# **LATTA ENGINEERING, PLLC**

**Re: Technical Review #1 Comments – PA22-019  
Groundhog PRD, 5110 83 Avenue NE, Marysville, WA**

Latta Engineering Ltd (LE) has prepared this letter to summarize project design revisions in accordance with your City staff technical review comments letter dated June 28, 2022 (see attached copy for reference).

DRAWING:	C - 4
SHEET:	4 OF 7

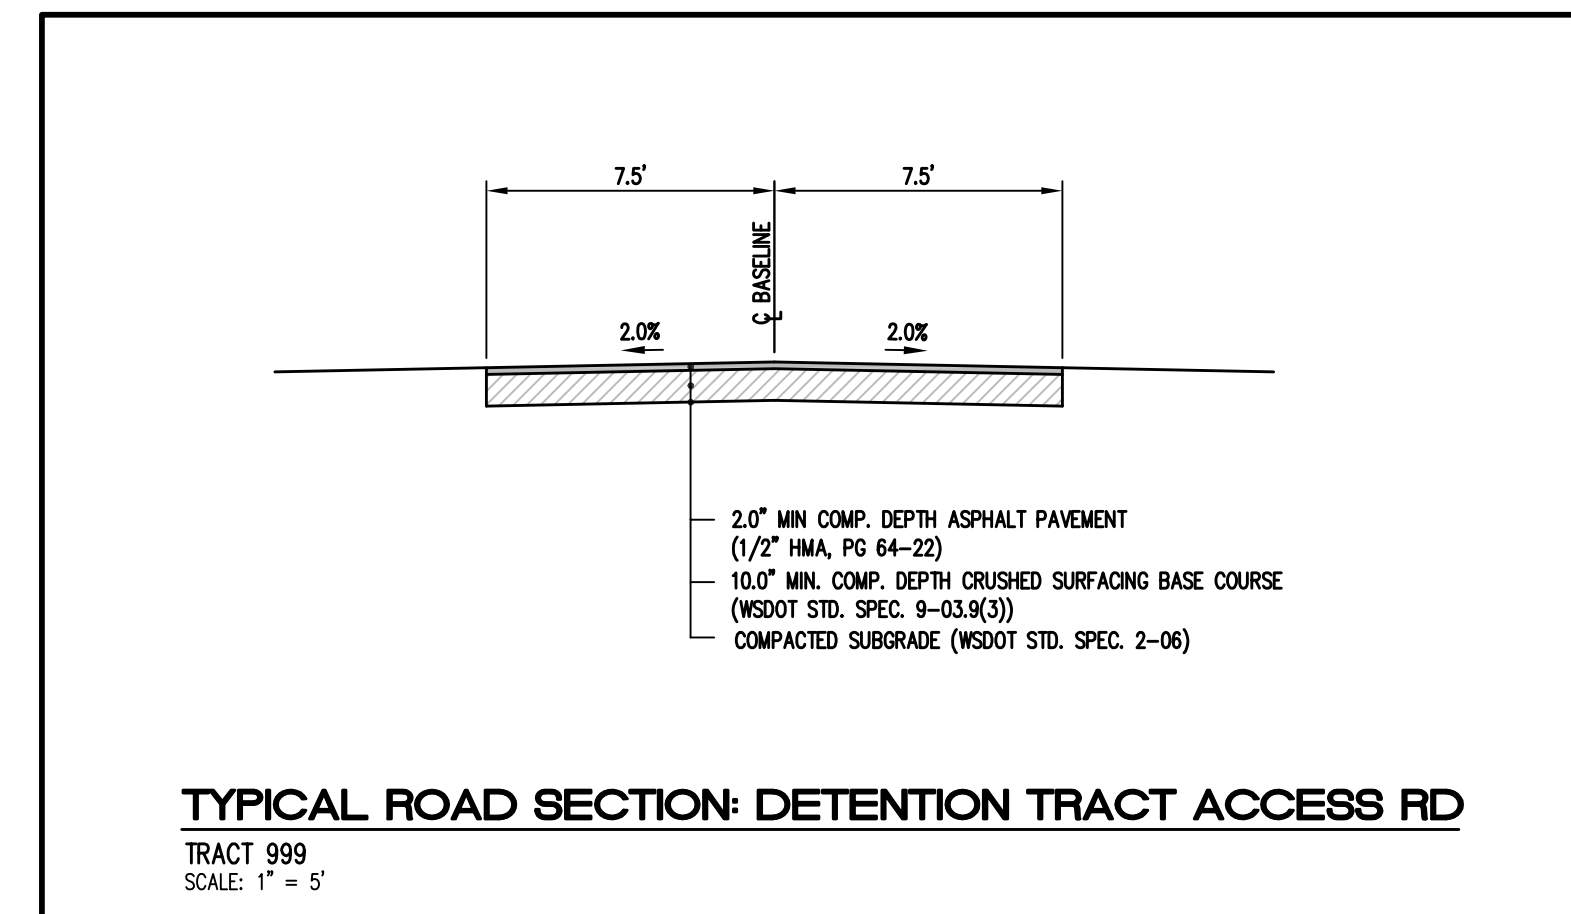
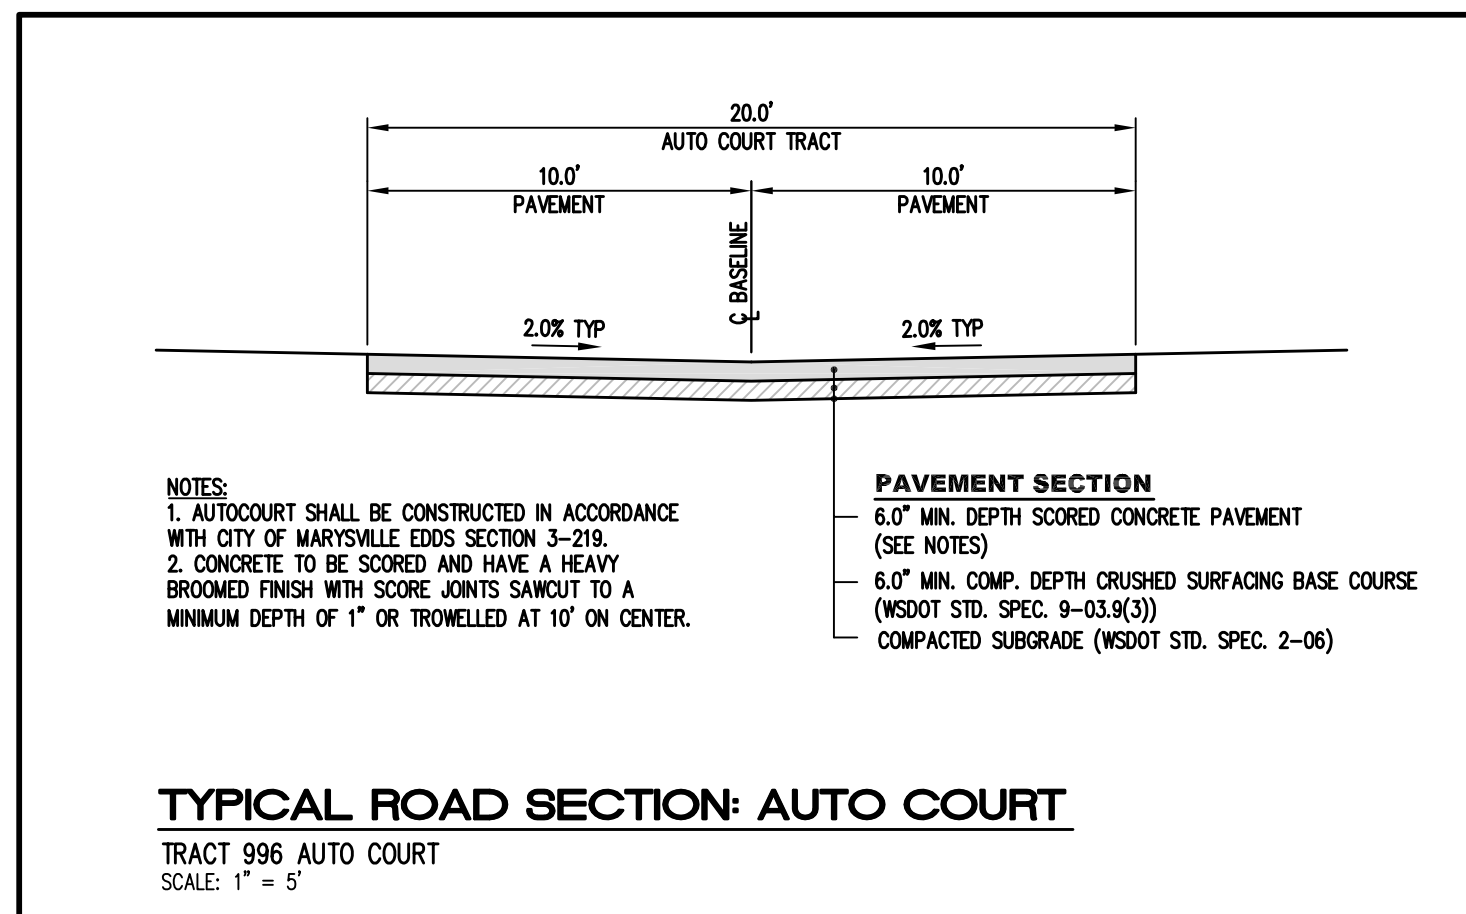
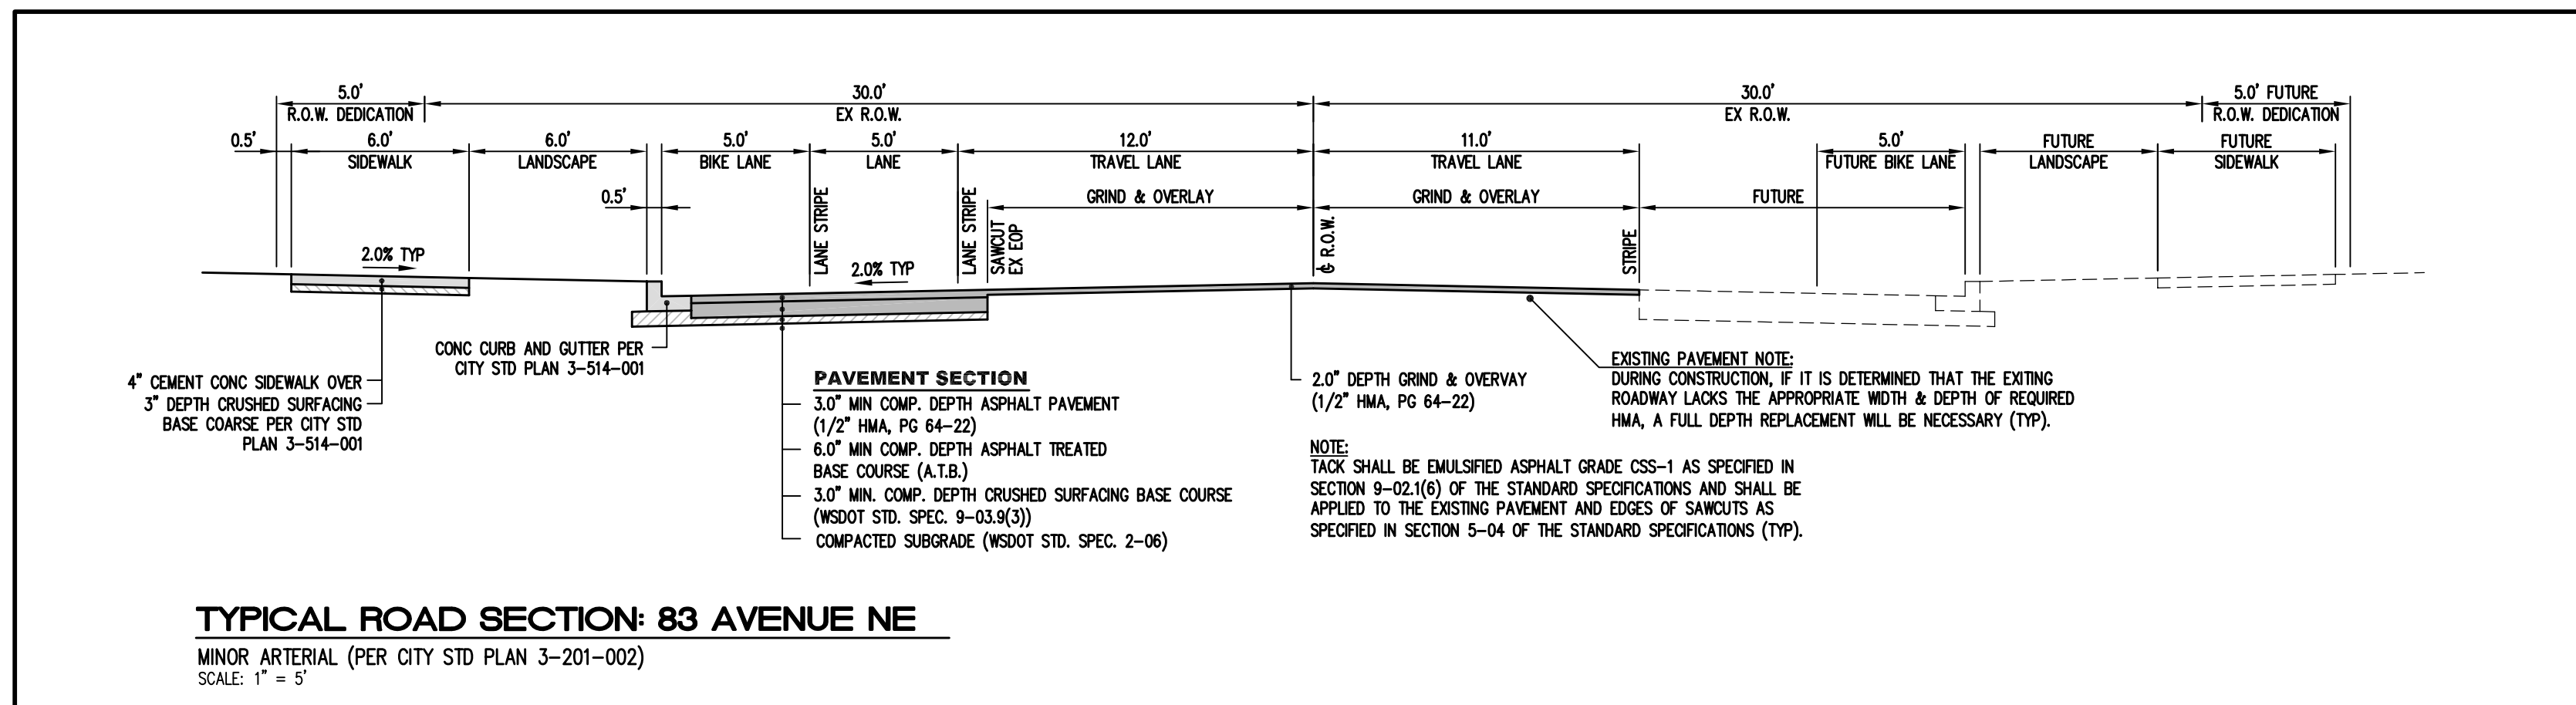
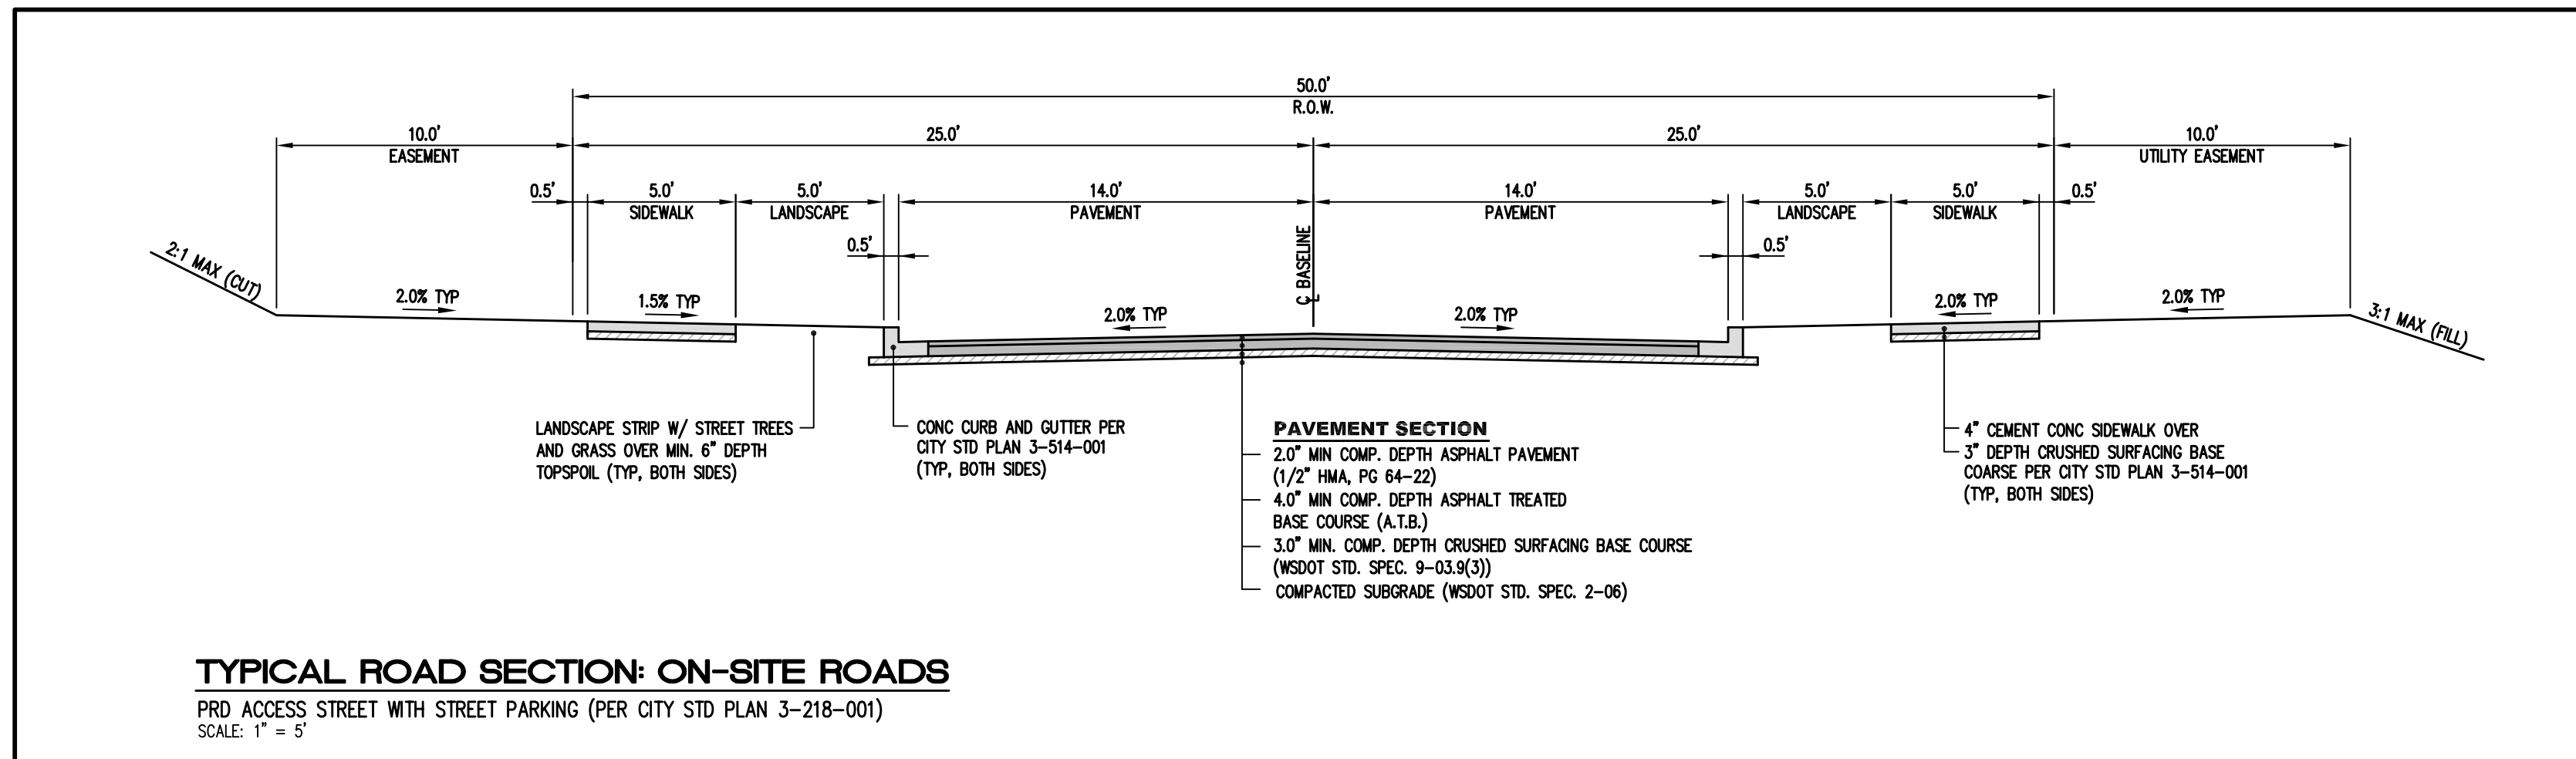
2. Based on review of Sheet C-4, there appear to be multiple retaining walls proposed with development. Please clarify how compliance with MMC 22D.050.030(4) is to be satisfied if the proposed retaining walls exceed 4 ft. in height:

- As shown on the revised preliminary *Grading and Composite Utility Plan (Sheet C-4)*, retaining walls proposed within the development will typically be less than 4 ft in height (see revised plan that includes top and bottom of wall elevations as requested).

- Lot 8 may be the exception (wall height is currently shown at 5 ft height). This wall is proposed to be terraced per City code requirement (terraced section will be separated by a 2 ft landscape bed).
